Planning Application Ref: Y/82/20/RES

Location: Land to the south of Ford Lane and East of North End Road, Yapton, BN18 0DS

Specific comments and areas of tree/development conflict identified from Planning Layout, Drg. no. 065 Rev. A

Mark Warwick
Tree Officer / Parks and Greenspace Team

Drawing Title Sections through Infiltration Basin

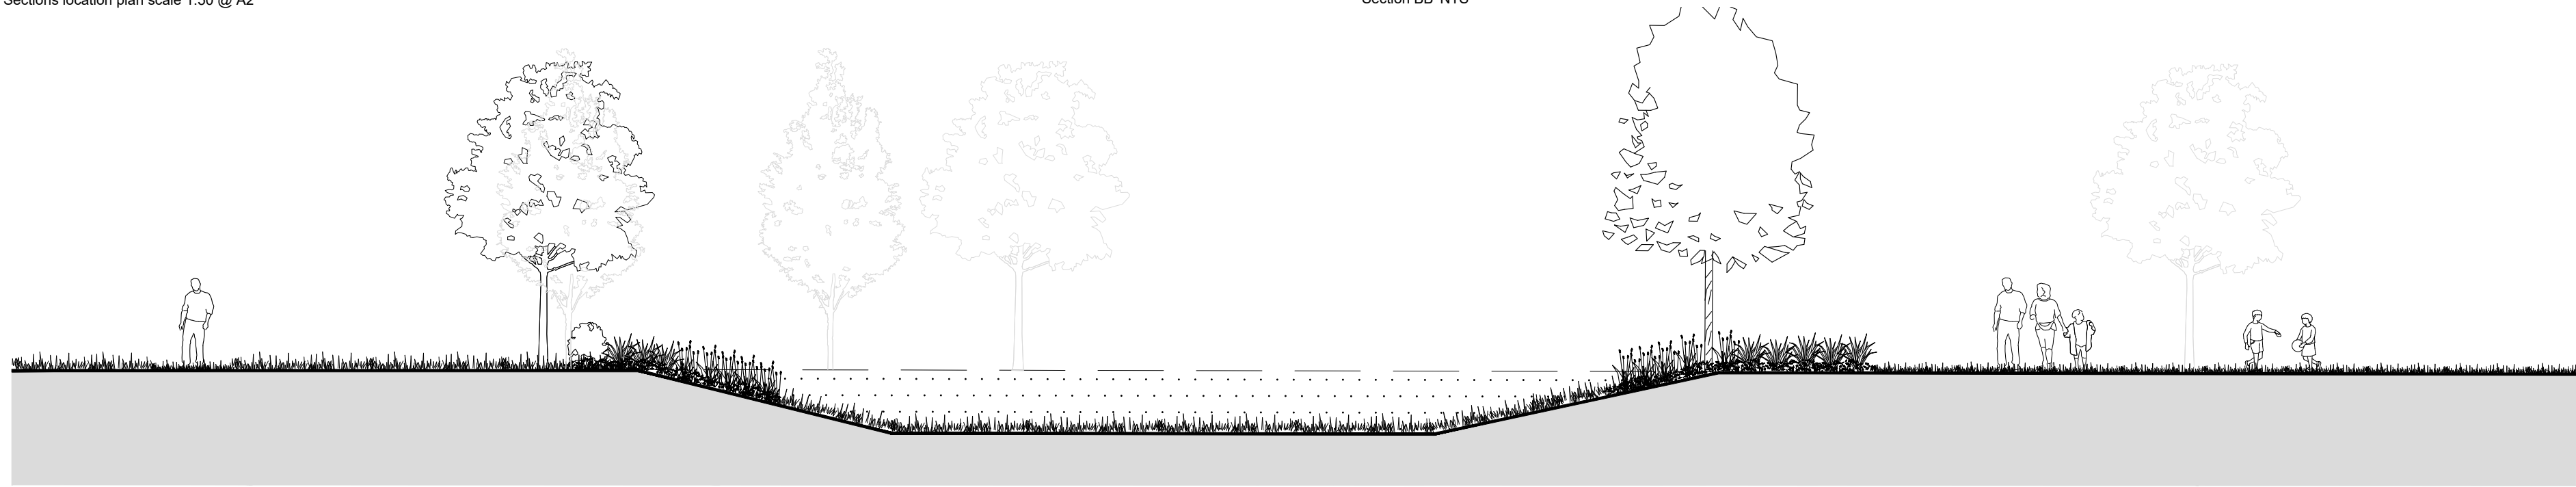
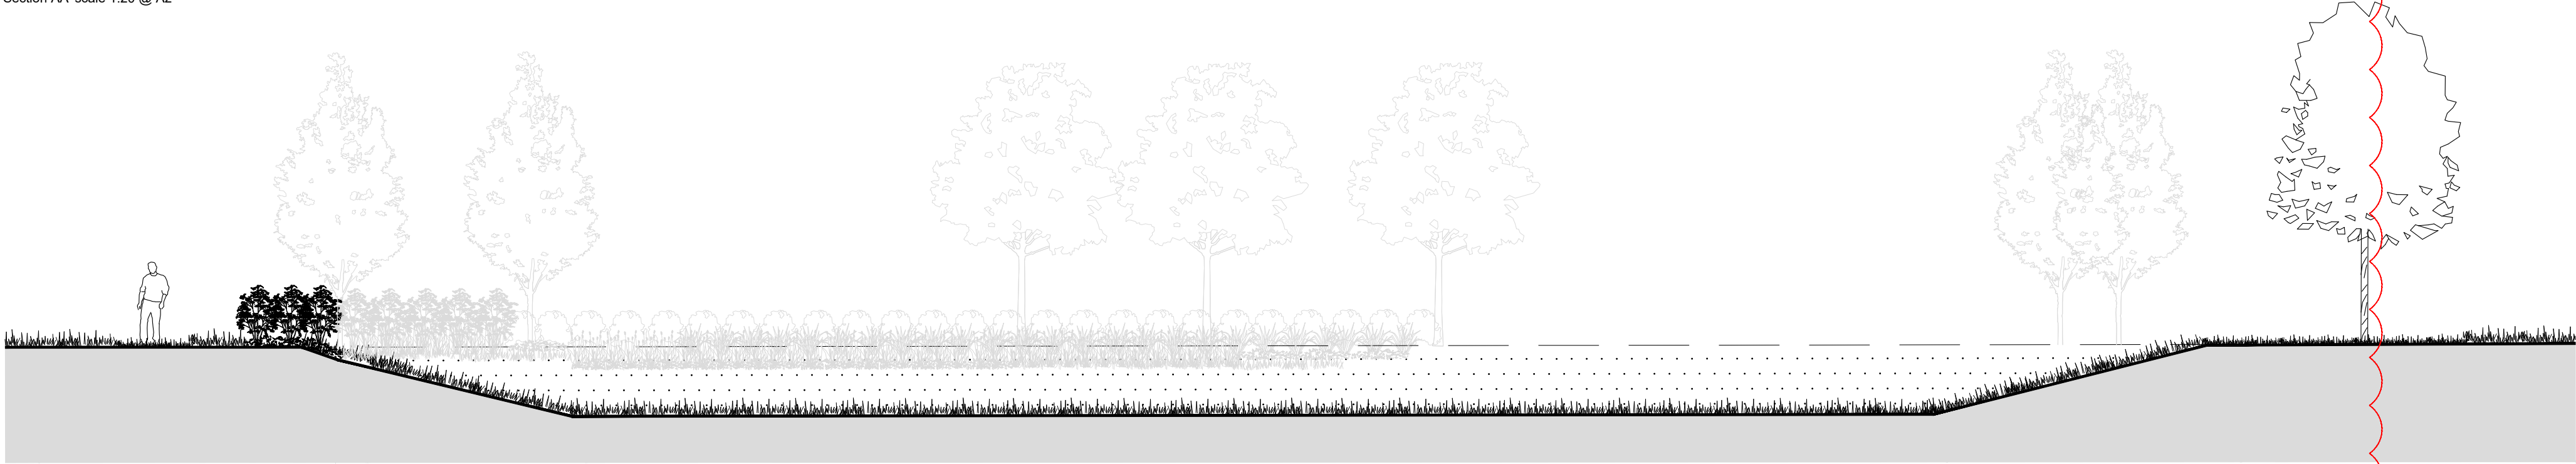
- **There appears to be a swale proposed to the east of the site (illustrated but not identified in any legend), which appears to intrude the root protection area of an important tree (opp. plot 29).** The siting of any SuDS feature without sufficient regard to existing and potential growth of retained trees is problematic and unlikely to gain the approval of Drainage Engineers. I urge revision of such a proposal and to allow for min. 3m easement outside of RPAs (plus 2m buffer zone) or to explore alternative locations within the site. **Unresolved** – Excavation is proposed within the RPA of T6 Oak (Category A, TPO). There is space to the west which can accommodate the swale without intruding into the RPA.
